Sea Link Energy Cable

**Appendix H6 to the Natural England Deadline 6 Submission**

**Natural England's Additional Comments on the Suffolk LVIA**

Planning Inspectorate Reference EN020026

**Plate 3.2 Preferred area of acid grassland enhancement**

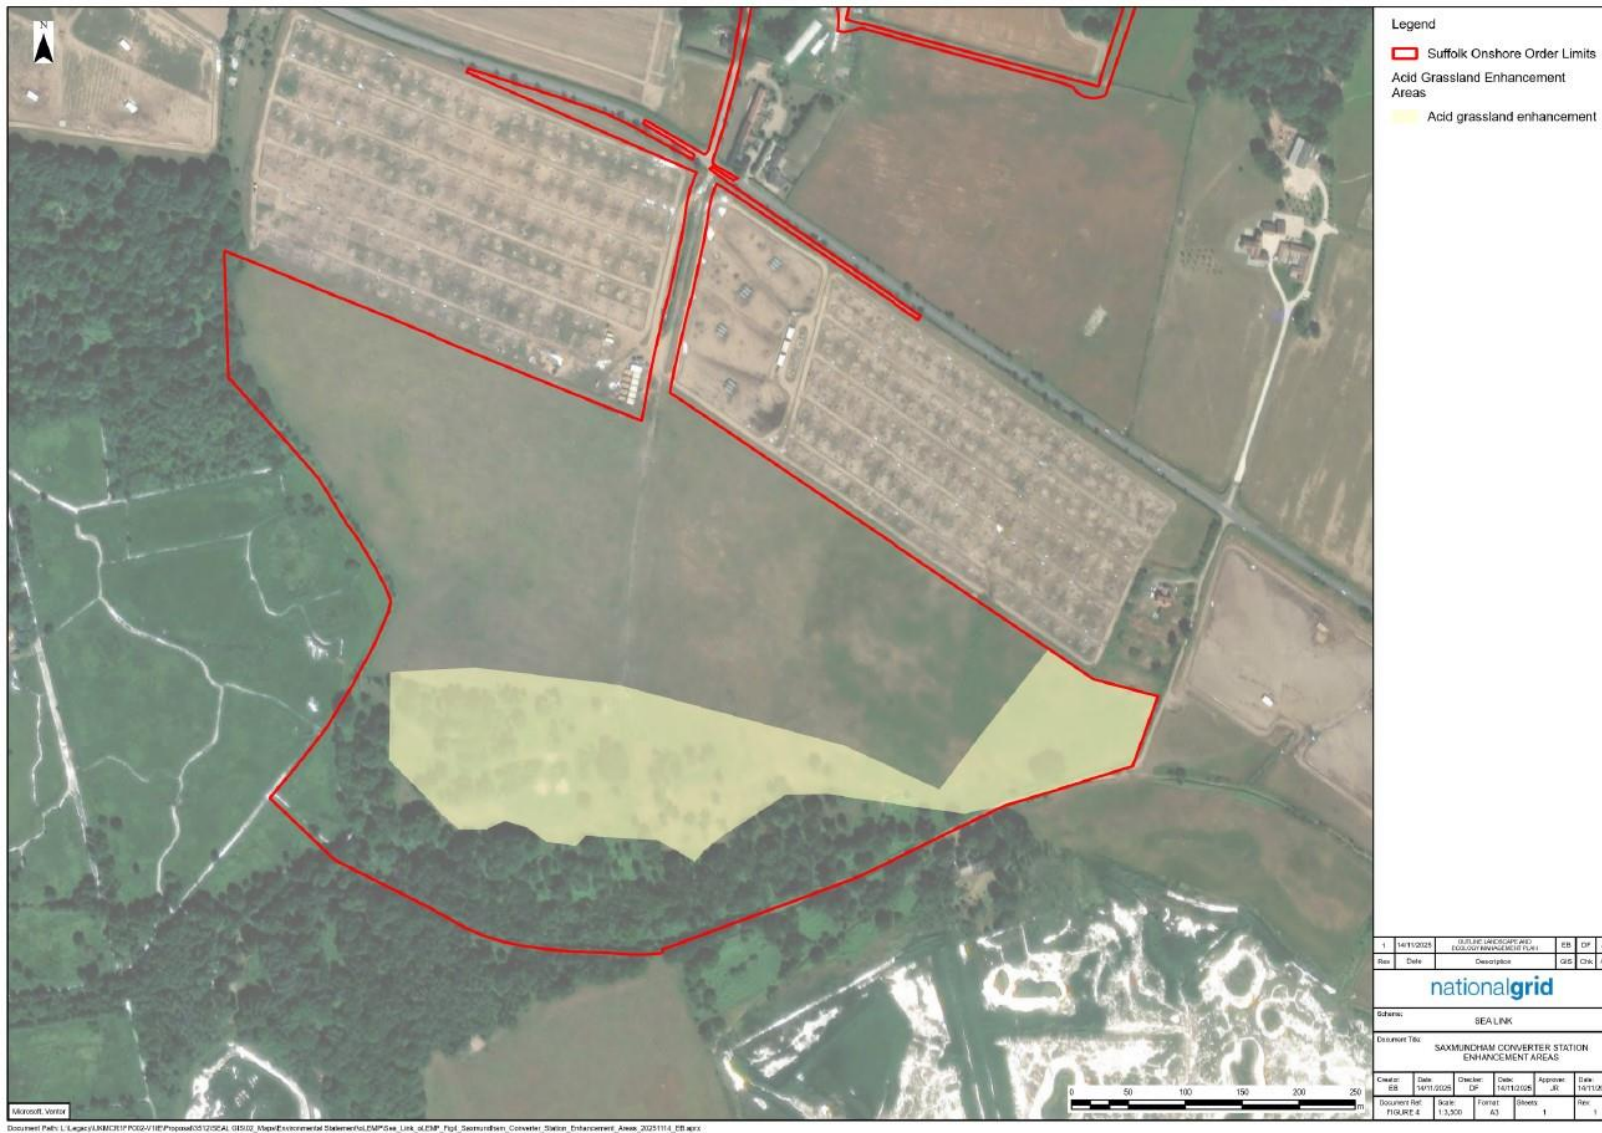
| 3 | Table 15.5<br>Ref 2<br>(cont'd) | <p>It is not clear how the 10-year management plan would be sufficient to provide the stated gains, either on ecological grounds or Landscape and Visual. This is a clear risk to the efficacy of compensation. Furthermore, the pre-commencement management of this area does not appear to be substantiated in the LEMP or Plate 3.2 within Document 9.47 [REP1120].</p>   | <p>This matter has not been addressed in the document</p>   |

| Advice  | Narrative  | Information required  |
|---|--|---|
| <p><u>6 ha area:</u></p> <p>We continue to advise that additional evidence is required regarding the baseline habitat type of this area (a portion of which appears to be deciduous woodland priority habitat). Information regarding soil pH and influencing factors such the adjacent agricultural land use, have not been evidenced.</p> | <p>Our advice relates to the feasibility of restoring acid grassland to the intended condition given the presence of the nearby pig farm and agricultural operations, and the requirement to provide suitable baseline evidence.</p> <p>The influencing factors of the pig farm and land use (on the pH of the soil for example, chemical drift, nutrient runoff) may restrict the project's ability to restore acid grassland as stated. This is therefore a risk to stated outcomes. The fact that the management is limited to 10 years is a further limiting factor.</p> <p>In addition, it is unclear if the rotation regime will include movement of the pigs in closer proximity to the 6ha area during the 10-year period.</p> <p>We advise that the influencing factors of the pig farm and land use (on the Ph of the soil for example) may restrict the project's ability to restore acid grassland as stated. This is therefore a risk to stated outcomes. The fact that the</p> | <p>The risks regarding the location of the proposed enhancement should be acknowledged and incorporated. They remain an unmitigated risk.</p> <p>Acknowledgement of existing biodiversity value of the area and how this will be maintained.</p> <p>Understanding the pH of the soil would help understand likely success of acid grassland restoration</p> |

| <p><u>10 year management plan:</u></p> <p>It is not clear how the 10 year management plan would be sufficient to provide the stated gains either on ecological grounds or Landscape and Visual. This is a clear risk to the efficacy of compensation. Furthermore, the pre-commencement management of this area does not appear to be substantiated in the LEMP or Plate 3.2 within Document 9.47</p> | <p>In addition it is unclear if the rotation regime will include movement of the pigs in closer proximity to the 6ha area during the 10 year period.</p> <p>When considering the time taken for directly affected habitats to establish and the limitations of the proposed area it is not clear how this area can be considered as enhancement.</p> <p>We again advise that employing trenchless techniques to avoid habitats should be adopted</p> <p>We note that the timescales involved in HDD and small area of acid grassland have been cited as a reason not to employ this technique.</p> <p>This does not reflect the loss of 7.5 ha of acid grassland within the Protected Landscape. We have advised that we do not agree that the term small scale is appropriate and that the impact to the special qualities of the Protected Landscape as whole is appropriate.</p> | <p>We again advise that employing trenchless techniques to avoid impacts to sensitive habitats should be adopted.</p> <p>This advice is in line with the mitigation hierarchy.</p> |
